**Jack Cloud**  
DRB Chairman  
Plaza Del Sol  
600 Second Street NW  
Albuquerque, NM 87103

Re: **4511 Paseo Del Norte Redevelopment**  
CORONADO CENTER

**Re: PDN Parcel 1-3 Parking Lot Reconstruction (Fed-Ex Bldg),  
4511 Paseo Del Norte, Traffic Circulation Layout  
Engineer's Stamp dated 4-28-14 (C17D022)**

SHEET TITLE  
**SITE PLAN**  
 SHEET NO:  
**C-103**

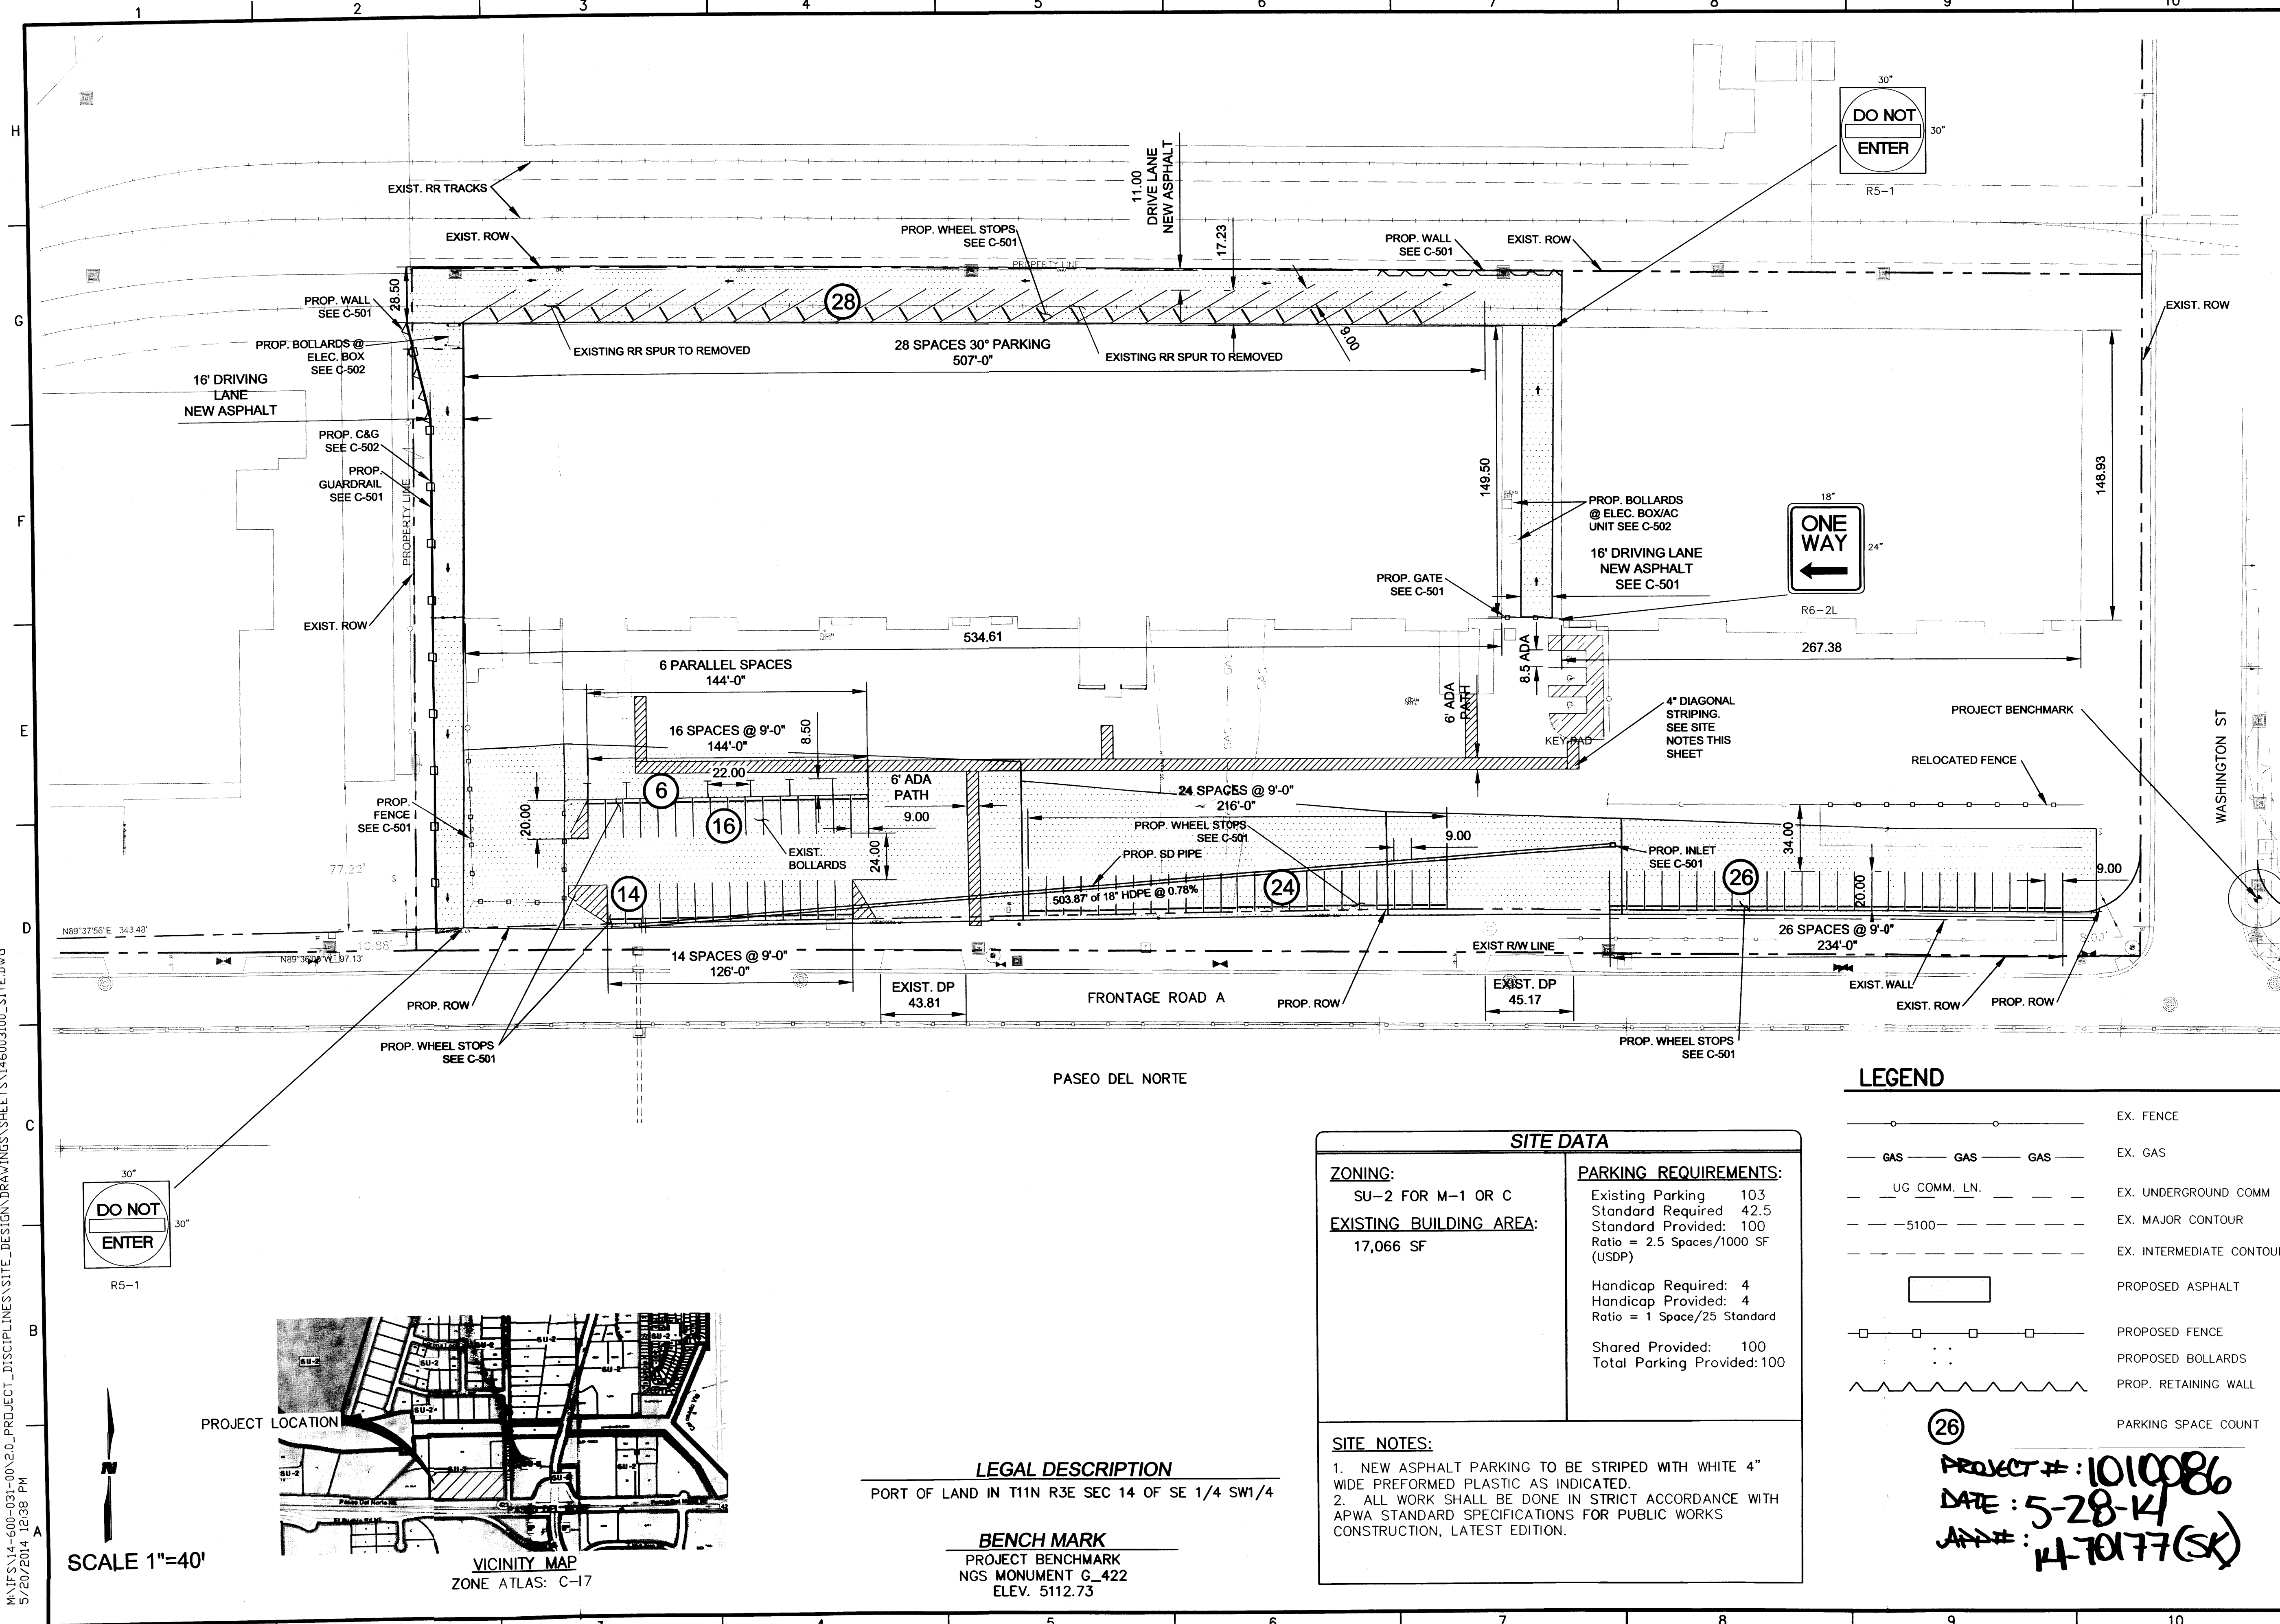
3. Paseo Del Norte frontage is under the jurisdiction of the NMDOT. Therefore the proposed new drivepad on the frontage requires approval from the NMDOT.

4. Site Plan must include, label and dimension all existing structures, site infrastructure, property lines, easements, public right-of-way, frontage streets, existing train tracks, and adjacent lots.

5. Site Plan must include, label and dimension all proposed changes to the current site, including infrastructure, property lines, etc.
6. Is landscaping required by zoning? If so, please provide landscaping plan with next submittal. Per the *Development Process Manual*, Chapter 23, Section 7, Part B.6, curbing should be used to separate landscaping from

- parking areas and pedestrian ways as well as providing a physical perimeter for harvesting water. This must be clearly shown on the TCL.
7. Please add the following note: "Landscaping and signing will not interfere with clear sight requirements. Therefore, signs, walls, trees, and shrubbery between 3 and 8 feet tall (as measured from the gutter pan) will not be acceptable in this area."

8. Please show a vicinity map.
  9. List the number of parking spaces required by the zoning code as well as the proposed number of parking spaces.
  10. The handicapped spaces must be a minimum of 8.5 feet in width.

11. The handicapped spaces must include an 8-foot wide van access aisle; all other aisles should be 5 feet in width.
  12. The development of this site must be in compliance with current DPM and ADA standards and regulations.

13. Per the DPM, a 6 ft. wide ADA accessible pedestrian pathway is required from the public sidewalk to the building entrances. Please clearly show this pathway and provide details.

14. Per the DPM, a 6 ft. wide ADA accessible pedestrian pathway is required from the HC parking stall access aisles to the building entrances.
  15. If a public sidewalk is required along the frontage, please place the proposed sidewalk at the property line, not the back of curb.

16. List the width of the existing driveways.
  17. Please show the location of the nearest driveway on the adjacent lot.
  18. List the width of the proposed turnout.

22. Per Chapter 23, Section 6, Part B.8.b of the City of Albuquerque *Development Process Manual*, Drive pad – Widths on Local Streets: 25 ft minimum for two-way access – 25' to 35' permitted, and 12'-20' for one-way drives (with appropriate signs and parking layout).

23. One-way vehicular paths require pavement directional signage and a posted "Do Not Enter" sign at the point of egress.
  24. Proposed 60 degree angled parking at rear of building proposes a 12 ft drive lane. Per the DPM, a 15.5 ft drive lane is required with 60 degree, one-way movement. However, the proposed widths of the spaces at +13 ft may allow a reduction in drive lane width. Deviation subject to DRB approval.

25. Please indicate that train tracks are proposed to be removed at rear of building to accommodate proposed parking.
